From: Roger Spencer <Roger.Spencer@arun.gov.uk>
Sent: 30 March 2022 09:58
To: Michael Eastham <Michael.Eastham@arun.gov.uk>
Cc: Sarah Burrow <Sarah.Burrow@arun.gov.uk>
Subject: RE: RE: LU/417/21/OUT - 71 units at Toddington ADDENDUM COMMENT

From: Roger Spencer
Sent: 29 March 2022 15:44
To: Michael Eastham <Michael.Eastham@arun.gov.uk>
Cc: Sarah Burrow <Sarah.Burrow@arun.gov.uk>
Subject: RE: LU/417/21/OUT - 71 units at Toddington

This Outline Application builds upon the approved Outline Application LU/47/11 and subsequent approved Discharge of Condition Application LU/17/19/DOC.

Drawing No. **D1970-PL300** Rev. **A**

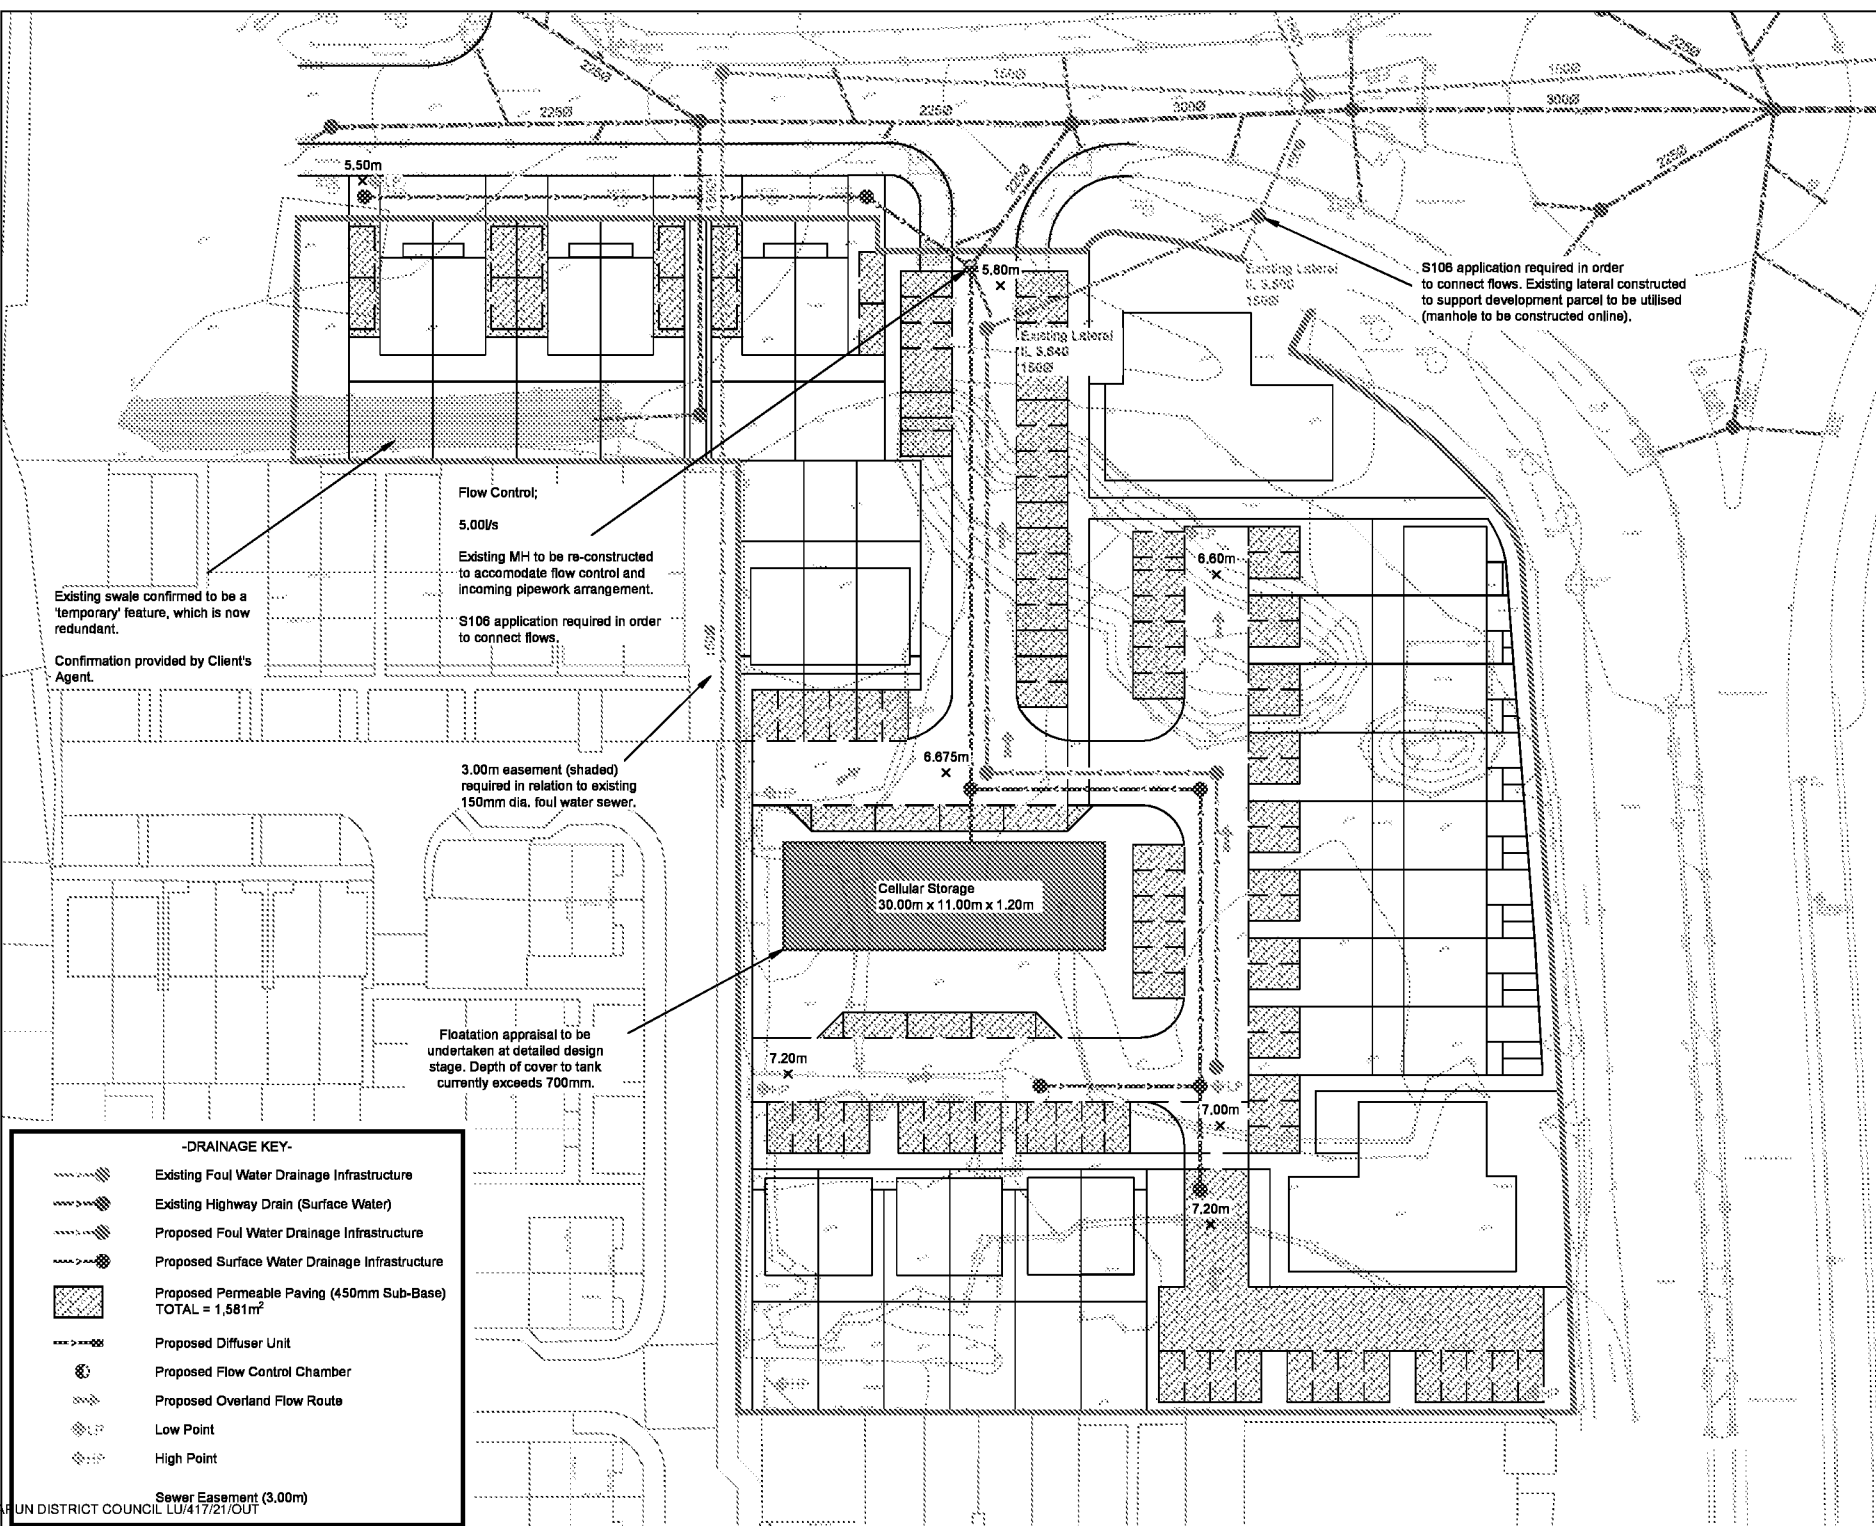
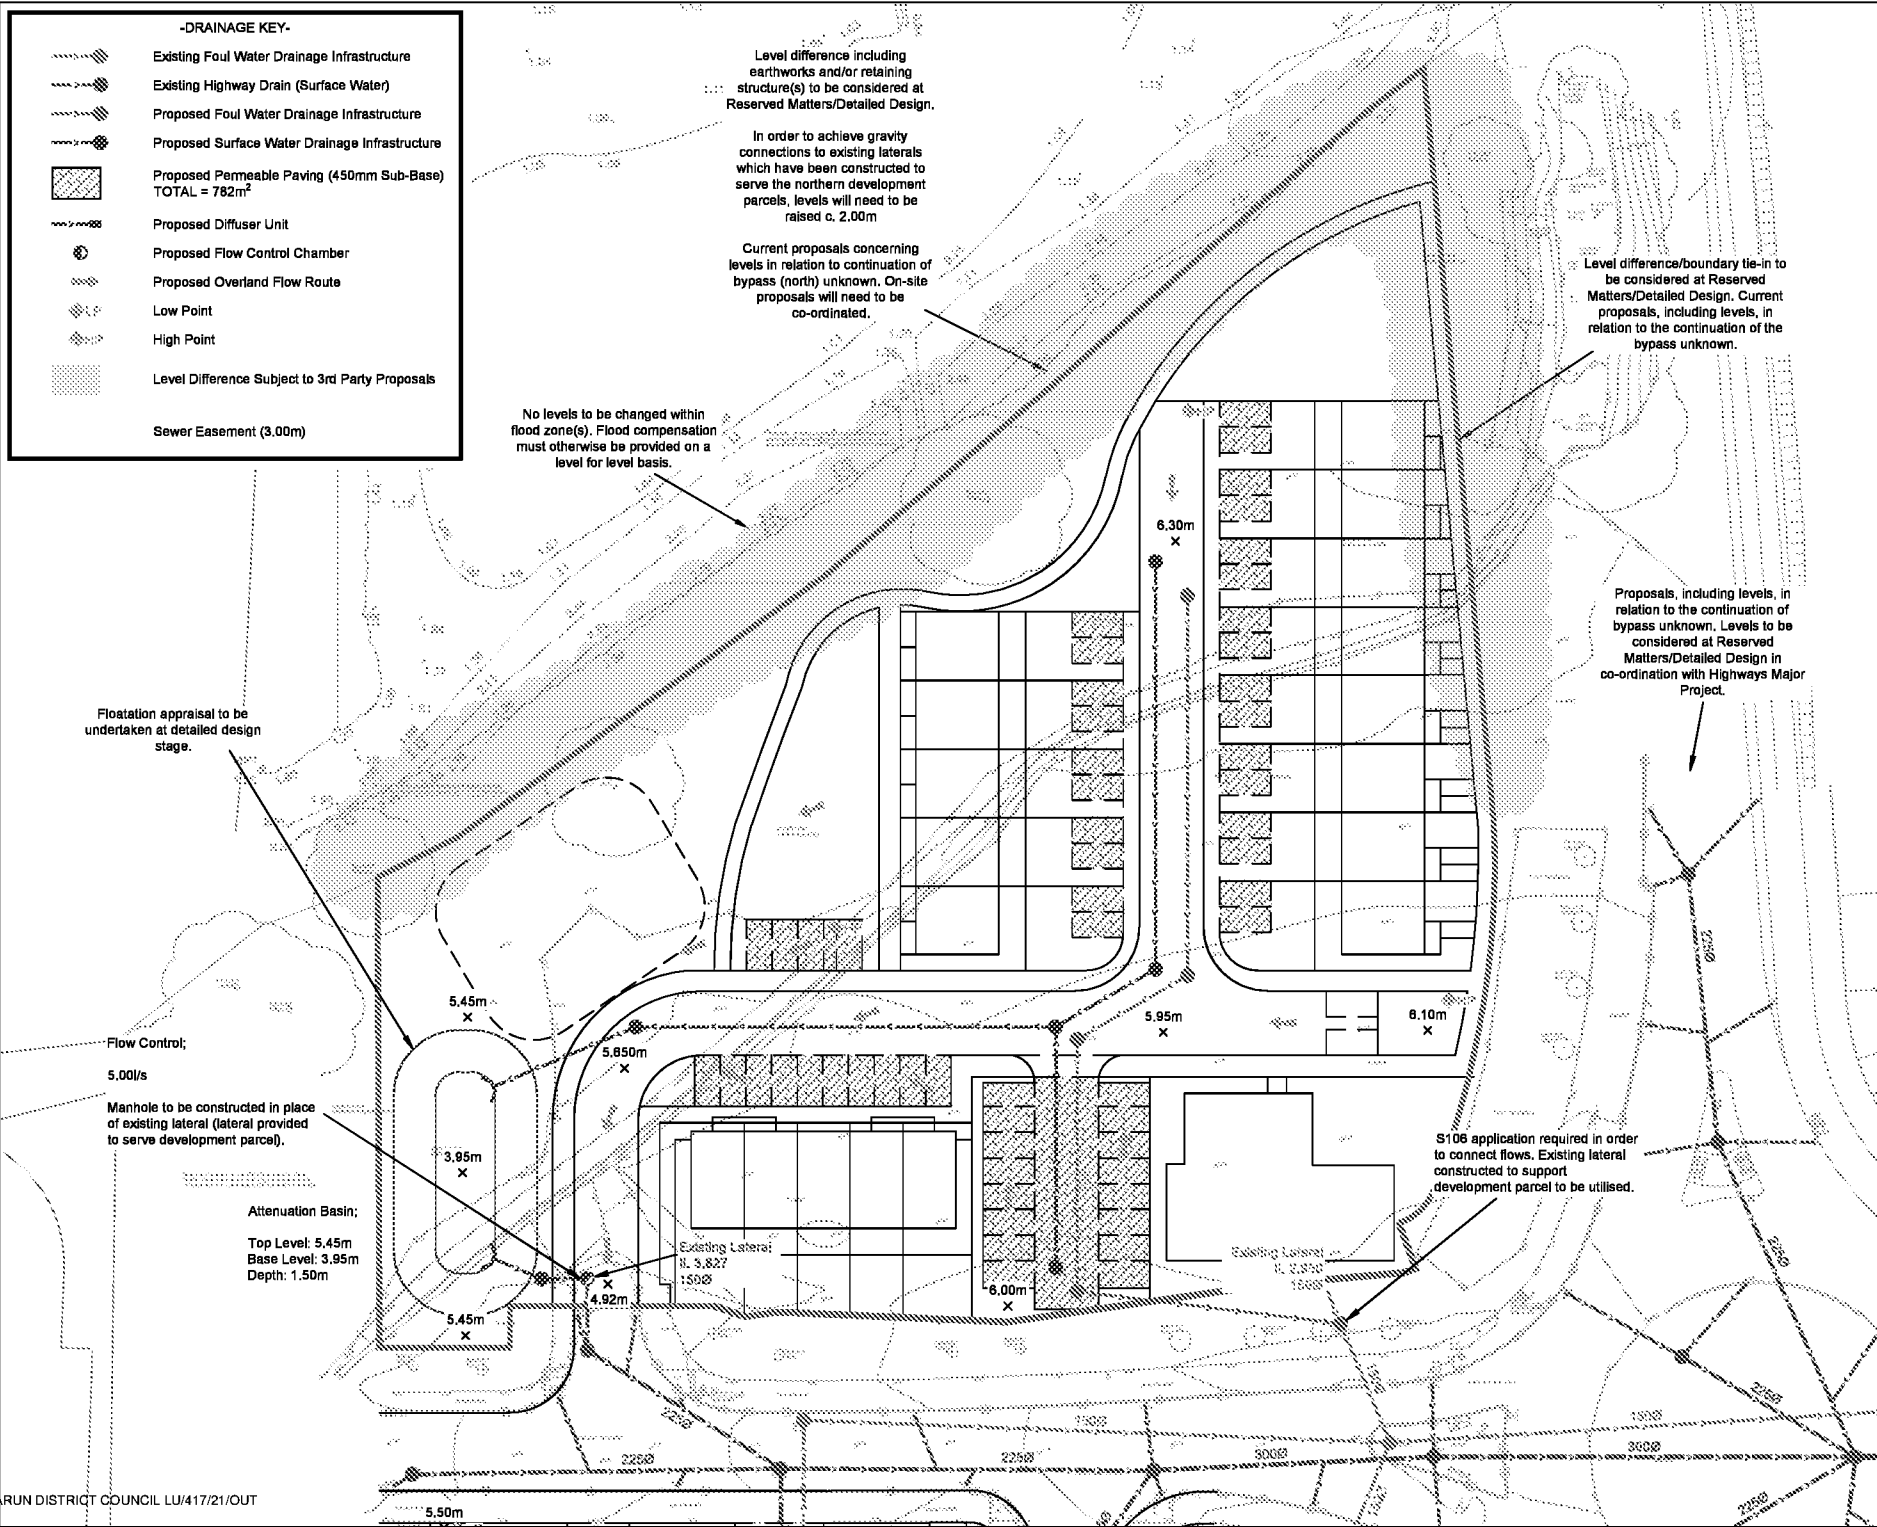
Please see below (in **BOLD RED**) an addition to my response of yesterday – it highlights the existing 150mm dia. Foul sewer that is mentioned below (easement clash) also has permeable paving over it. This sewer is not shown on our records as being adopted by Southern Water but it may be a update timing issue. The sewer is shown on Drg D1970-PL300 (A)

It is noted that there may be a conflict with an existing foul sewer easement running north/south in Site A and one of the Site A units that faces north. This is shown on Drg. D1970-PL300(A) – this drawing also shows that there is to be permeable paving over an existing 150mm dia. Foul sewer – I am not sure about the status of this existing sewer but if it is, or will be, adopted by Southern Water, there may be an issue regarding permeable paving over their apparatus. There would also seem to be a 225mm dia. Surface Water sewer, serving the swale behind 65-85 Hinchcliff Drive, which flows north-east to the manhole in the entrance to Site A. This is not shown in LU/417/21/OUT drawings but is noted in a LU/17/19/DOC drawing.

This does not alter my No Objection comment but will need clarification at Detail Design Stage if you are minded to approve the Application.
